5 November 2018

Your Ref: 3/2018/0750

Re: Twitter Barn, Twitter Lane, Waddington

Org N^o 415/2/5
 Rev. C

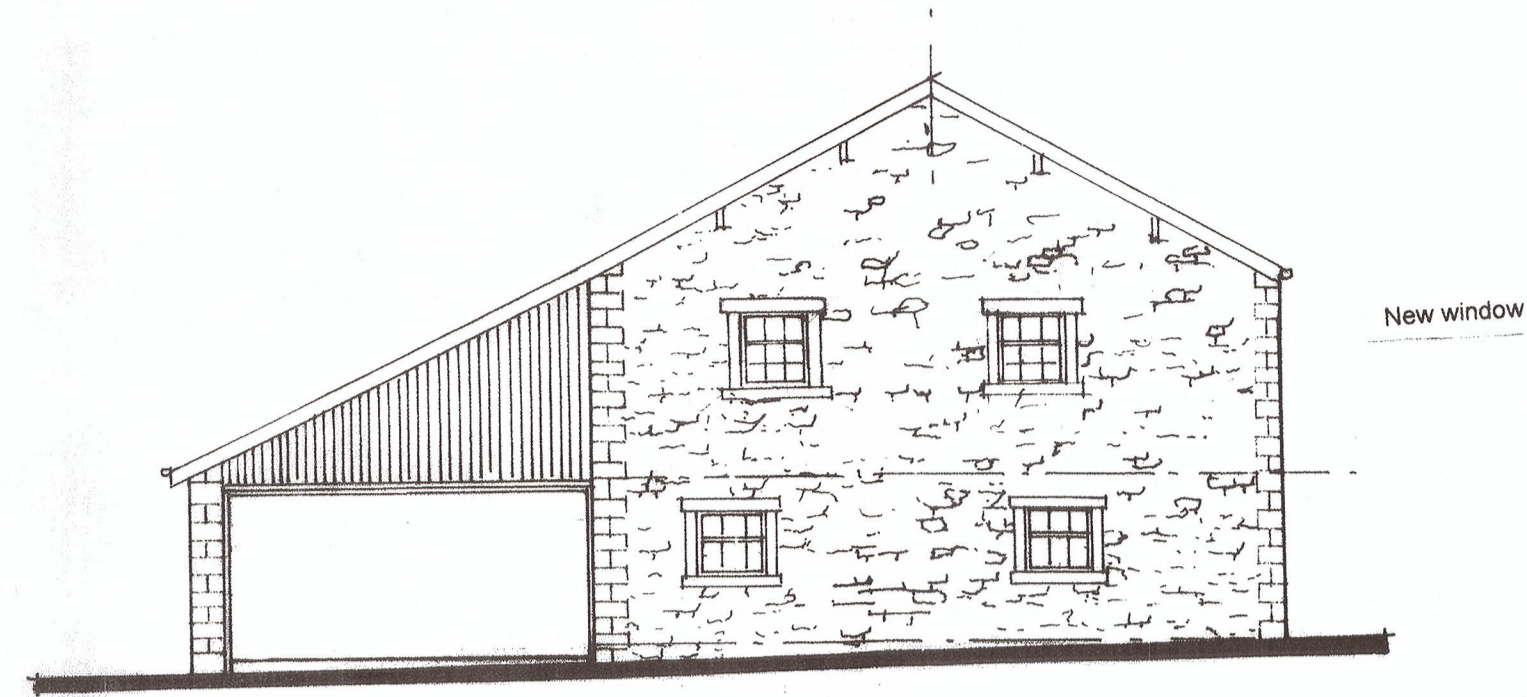
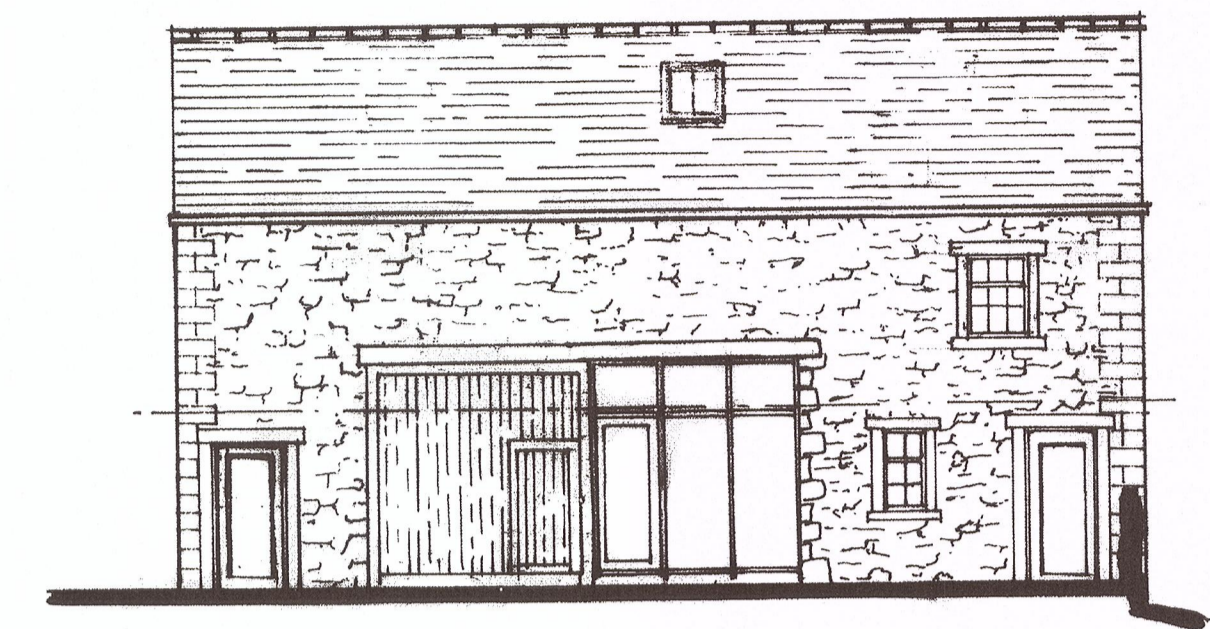
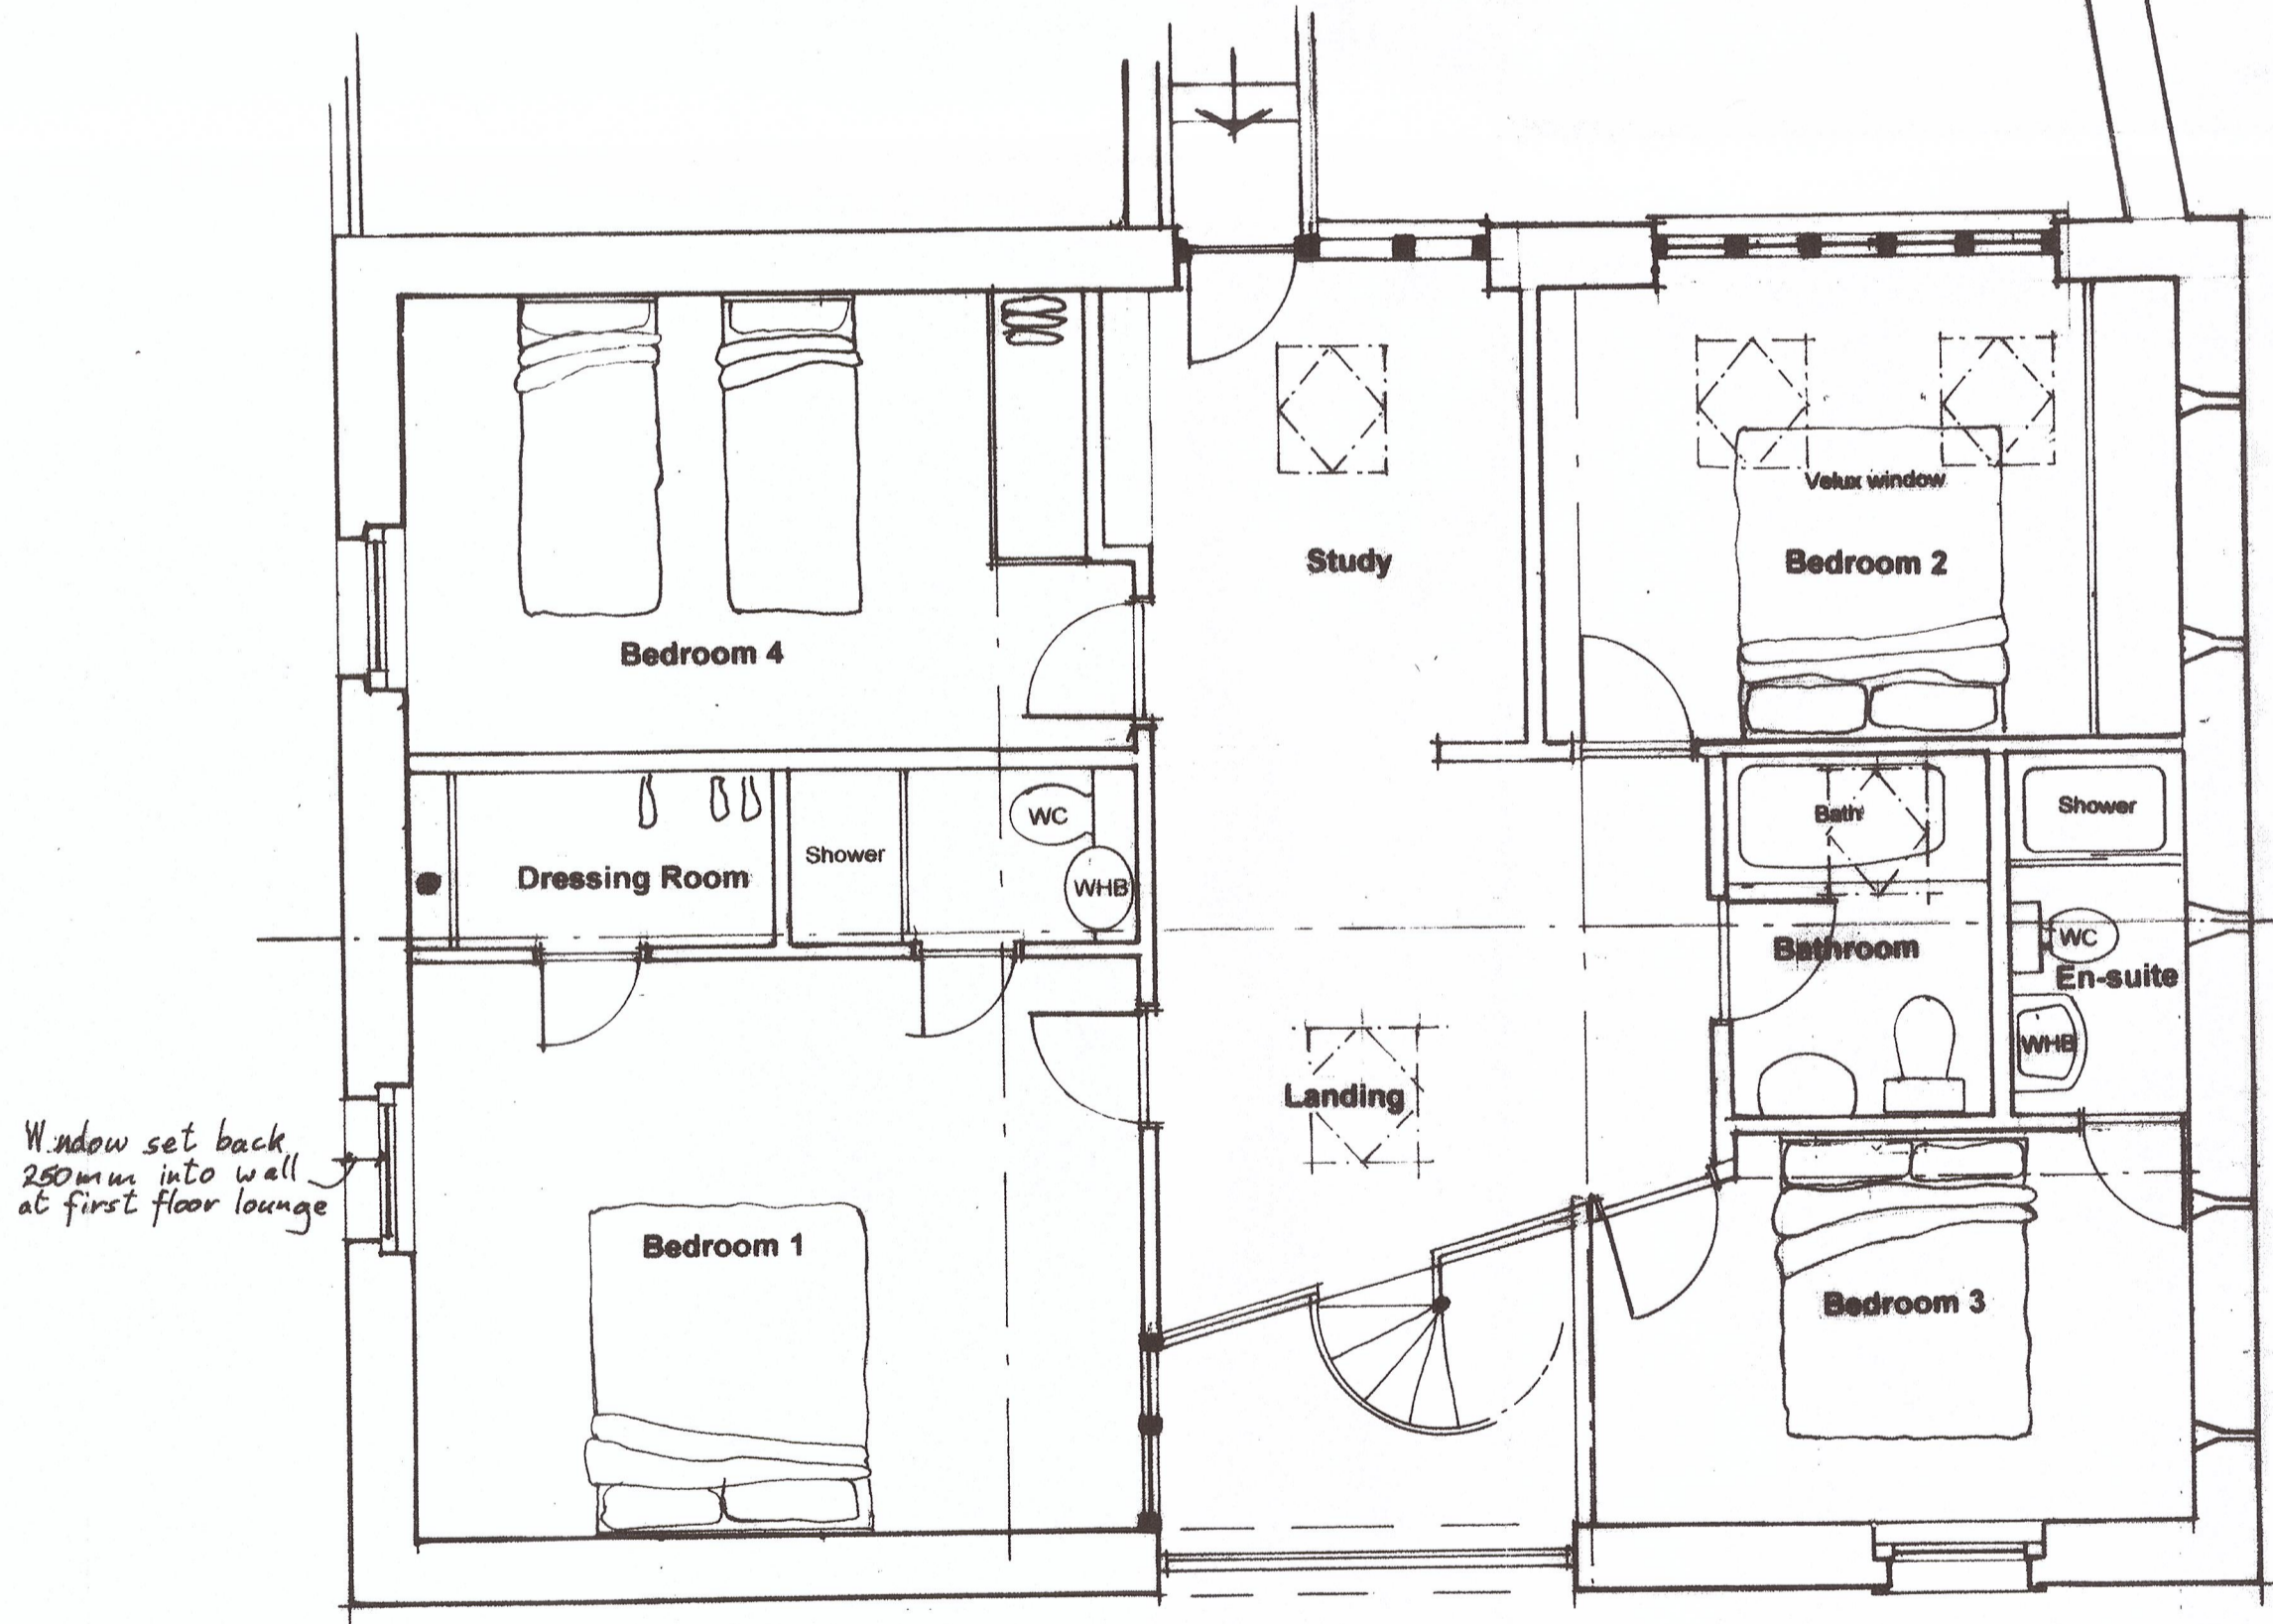
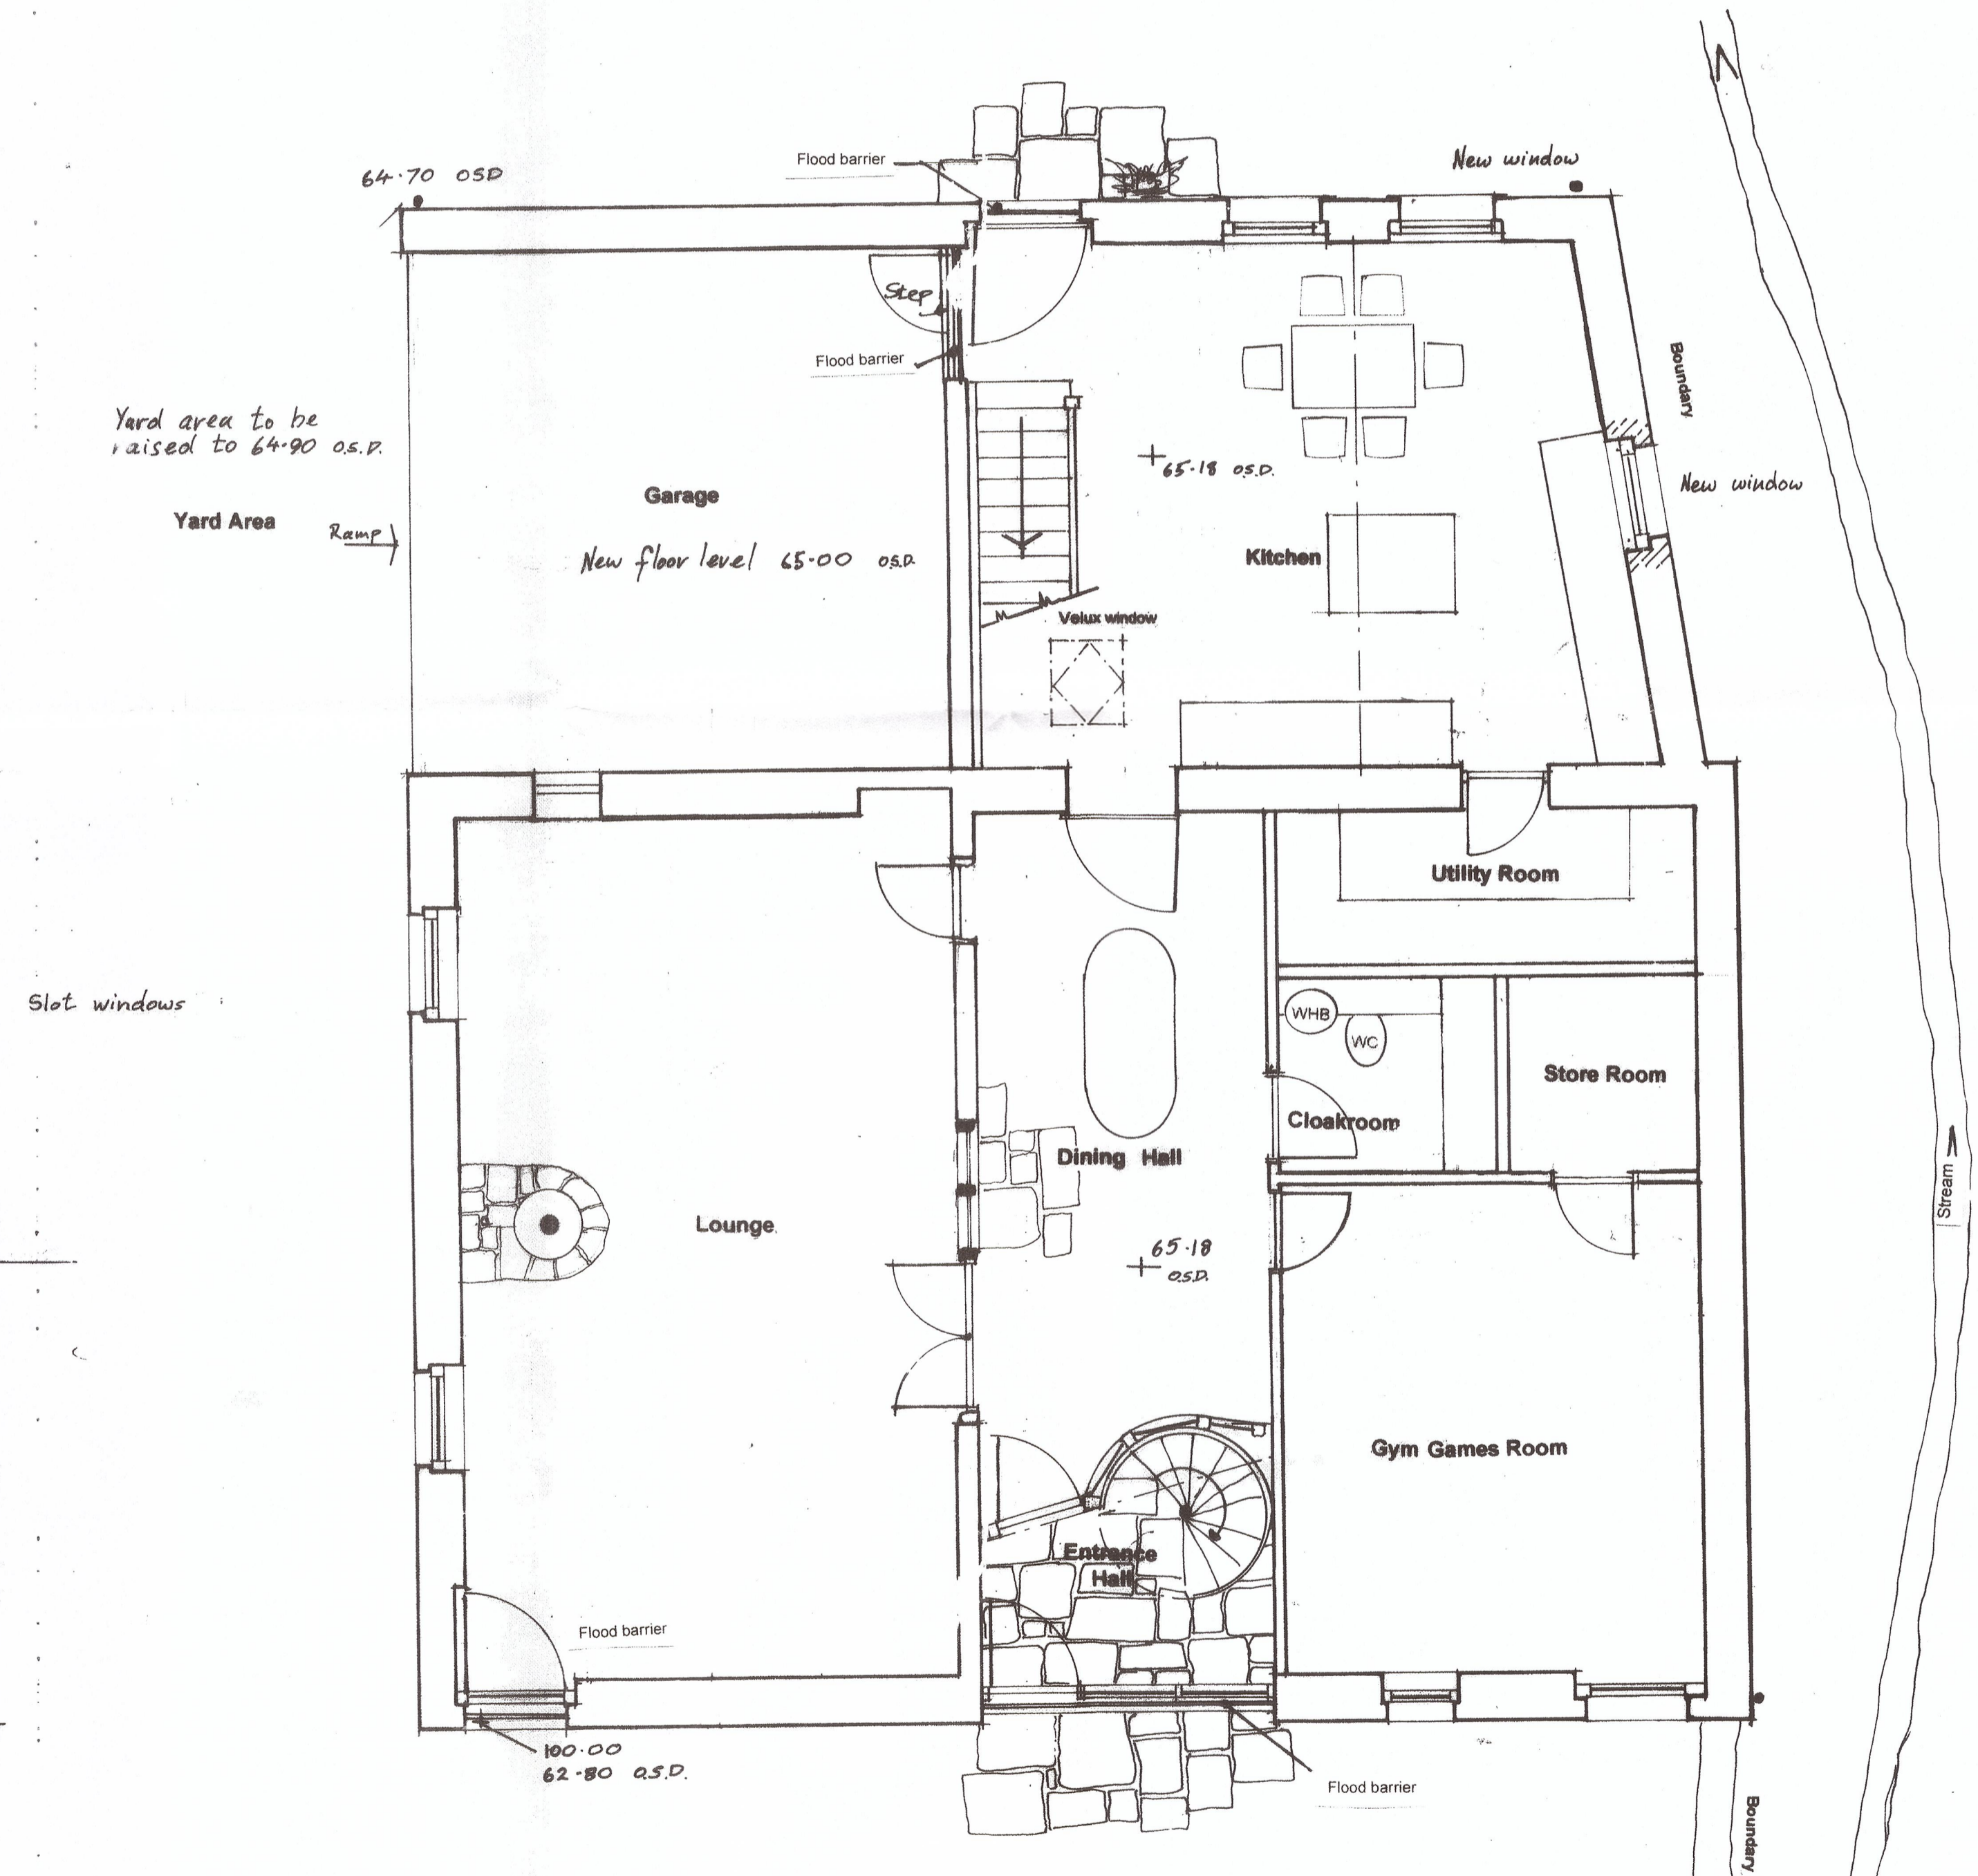
As in Mr Pye's email of 17 October, we can now respond to your concerns:

1. We will return the main barn door to the barn although this will be kept open at all times as shown on drawing 415/2/5C
2. We will remove two of the three low profile heritage roof lights to the front (south east) elevation and one will remain to give light to the landing. We will place a further roof light to the rear (north west) elevation which will provide natural light to the bathroom. This will also be low profile, heritage style.

The ground floor bedrooms will be re-designed to be on the first floor as shown on drawing 415/2/5C. The other modifications for the risk of flooding are as follows:
